Our Ref: EP/34/11/NMA

**Application for a Non-Material Amendment following a grant of
planning permission EP/124/10
to change round porthole window in north elevation to diamond
shape and render to part of elevations changed to weatherboarding
Seaside Cottage, South Strand, East Preston**

DRAWING NUMBER **10066/05a**

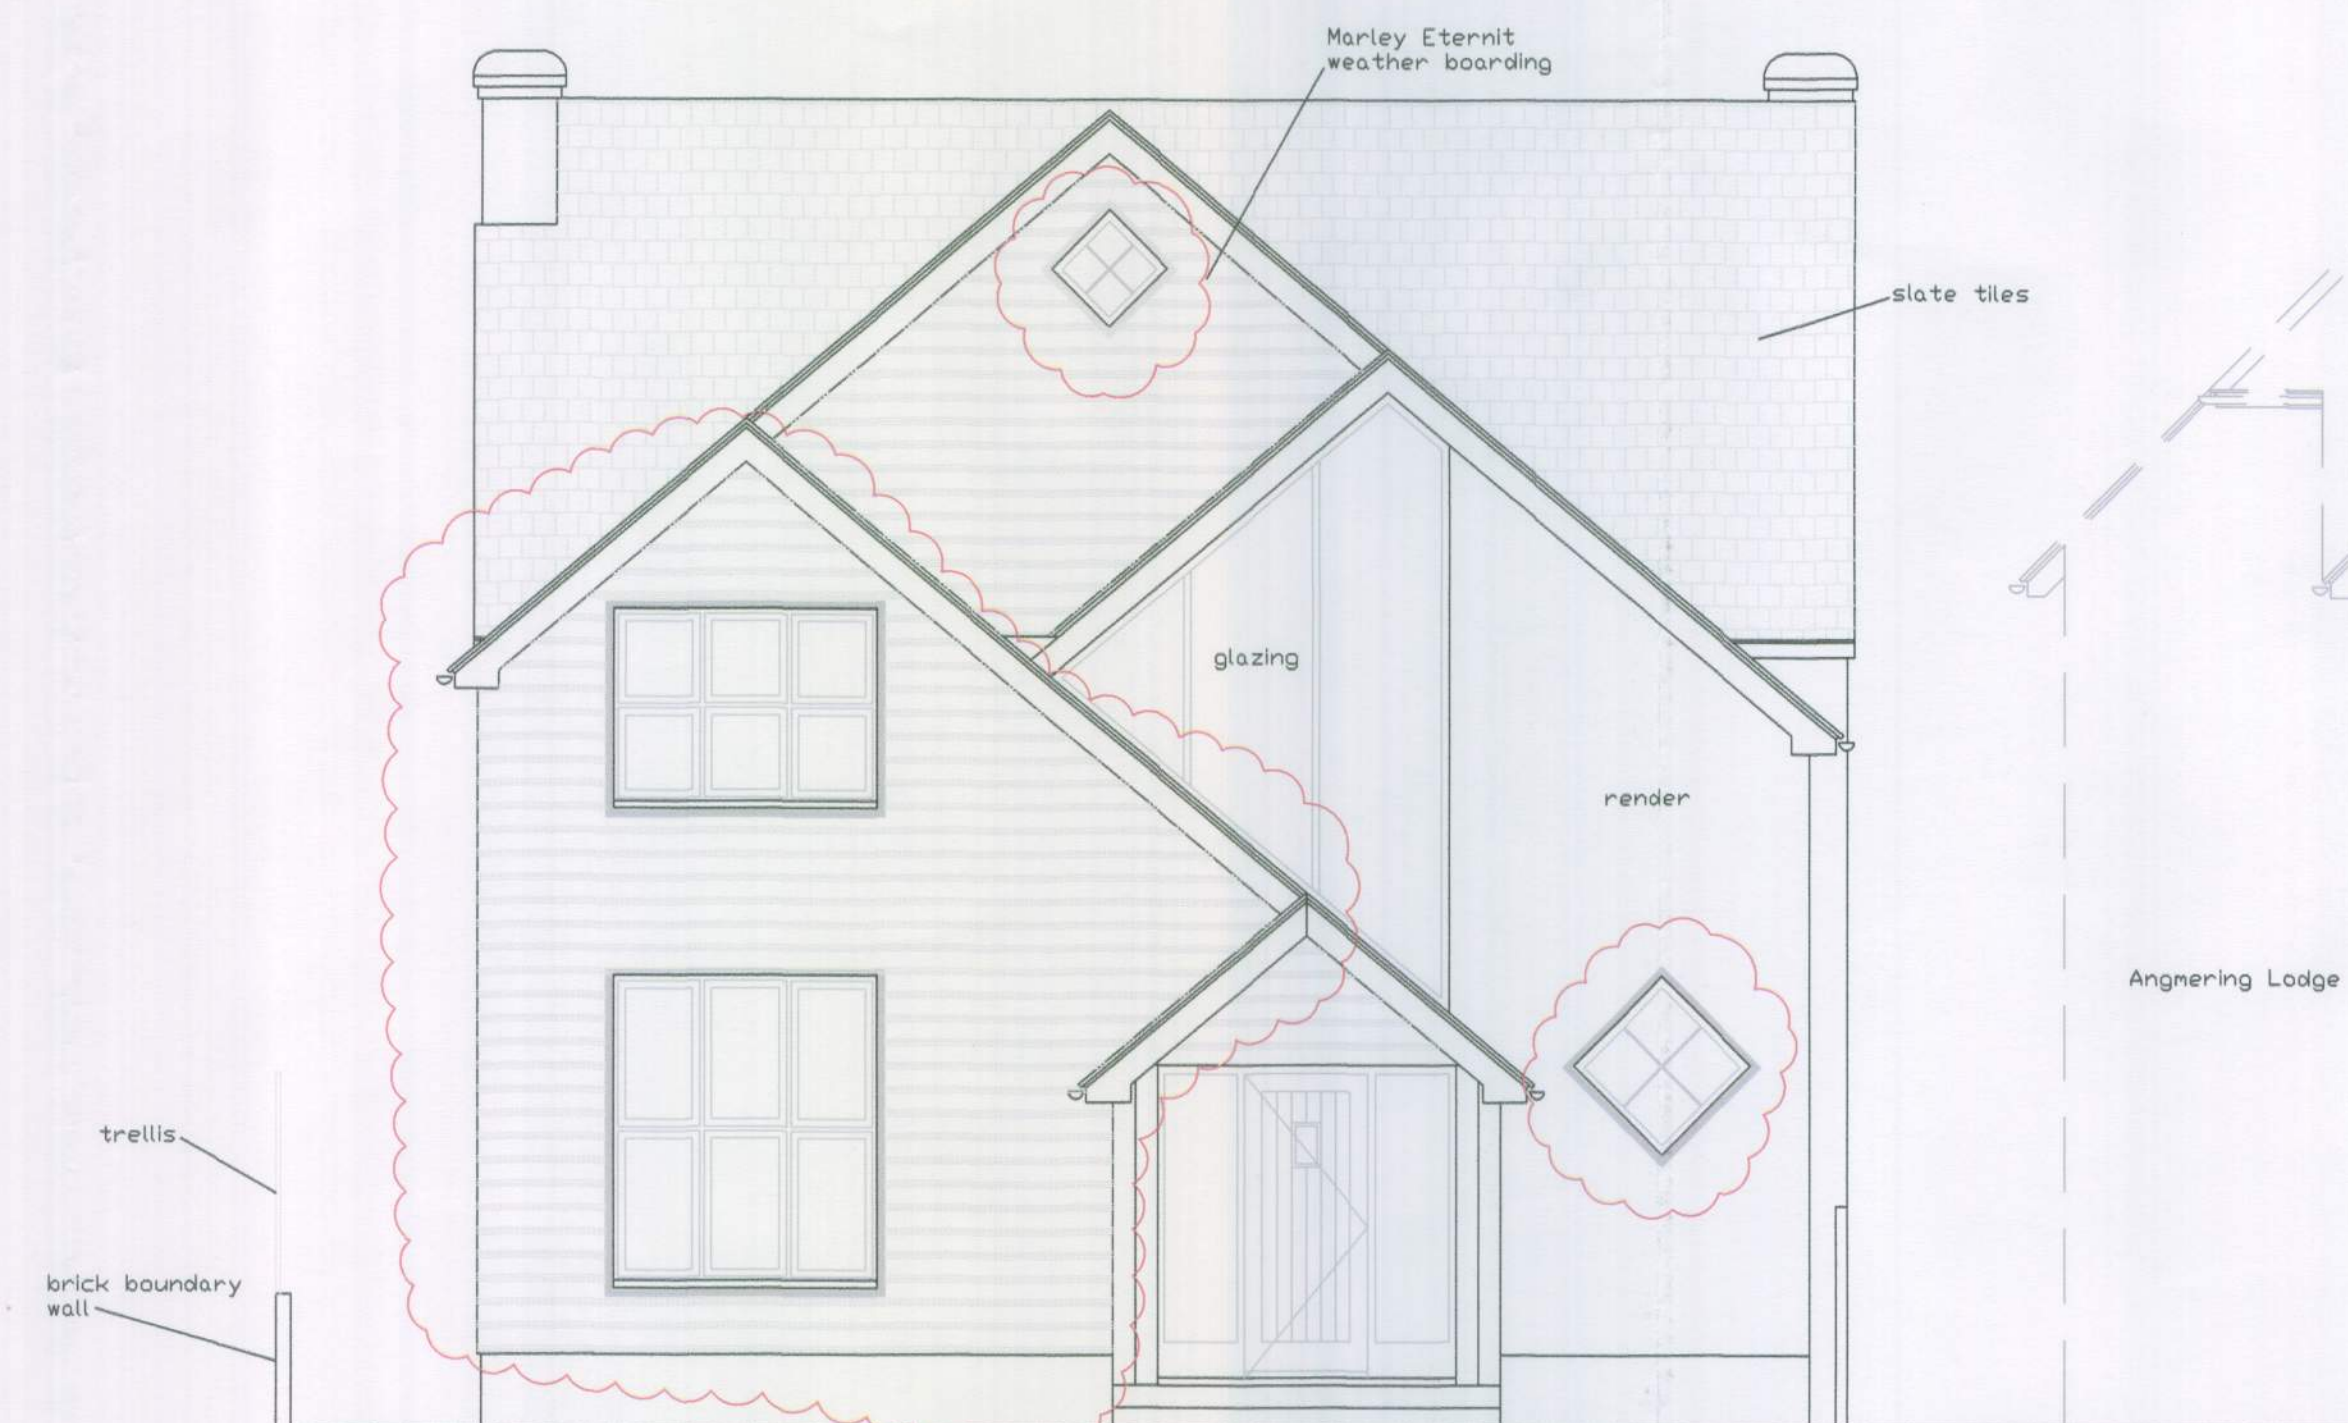
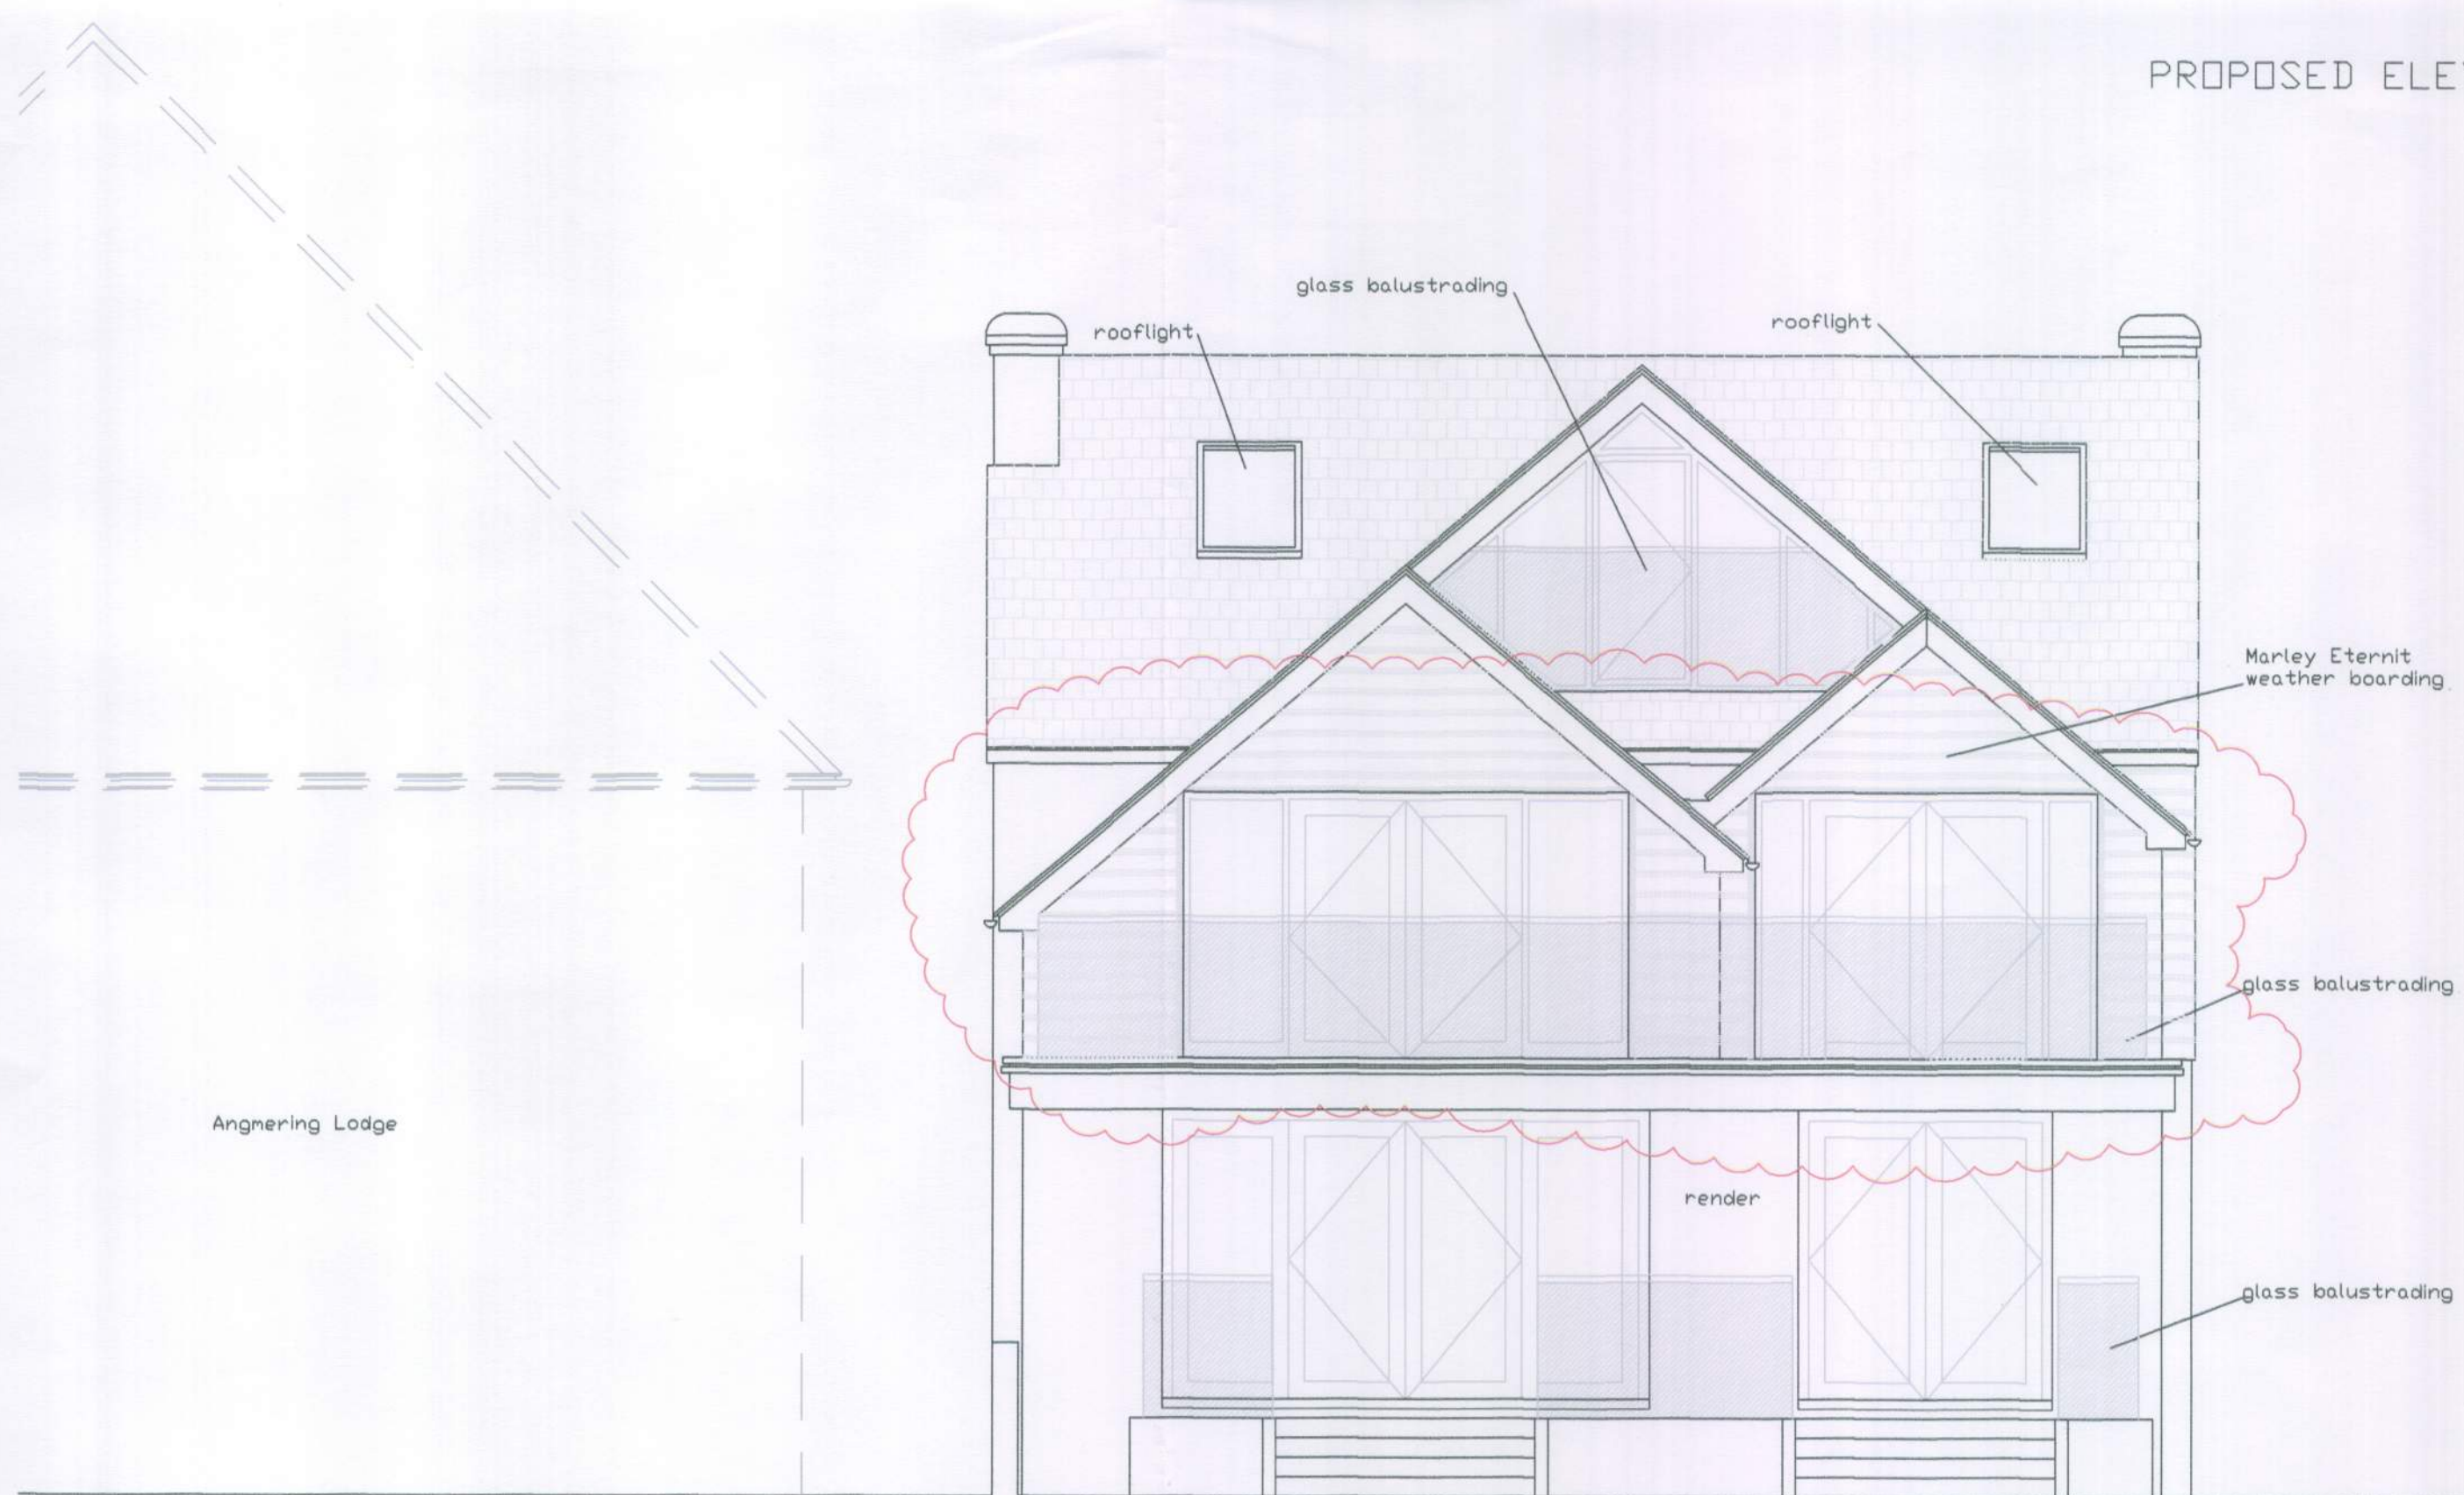
I am pleased to confirm that a diamond shape window to the north elevation to replace a porthole window together with render to part of the elevations changed to weatherboarding will be acceptable for the approved application EP/124/10. Please note that your submitted plan 10066/05A now becomes the approved plan for the development.
